Please ask for: Ms Iqraa Malik
Email: iqraa.malik@terraquest.co.uk
Telephone: 0121 234 1390
Our Ref: Y/54/22/HH
Your Ref:
Date: 3rd May 2022

Application for Planning Permission for Works or Extension to a Dwelling

Development: Demolition of Existing Garage and creation of new 2 Storey Side Extension to provide.
Location: 14 Park Road Yapton BN18 0JE

Site Plan 1:500

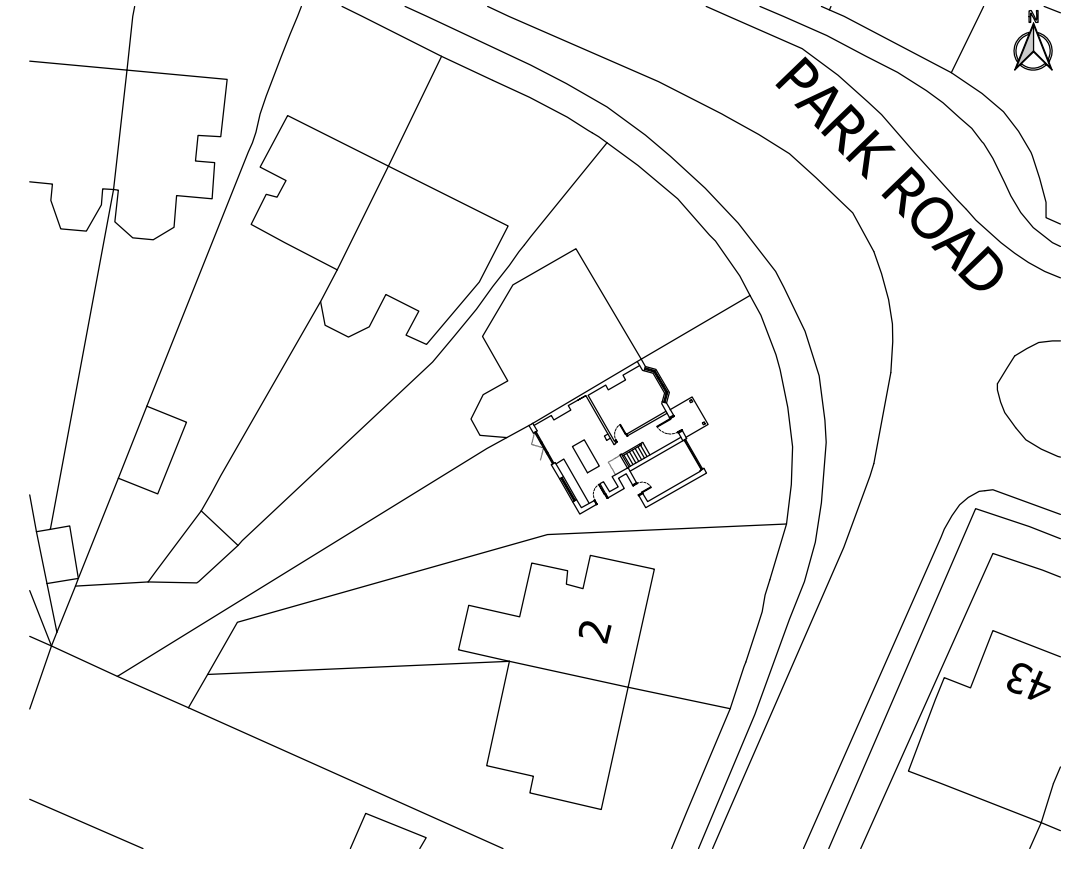
Dimensions: You are required to add dimensions on the block plan from all extension(s) or works to all site boundaries.
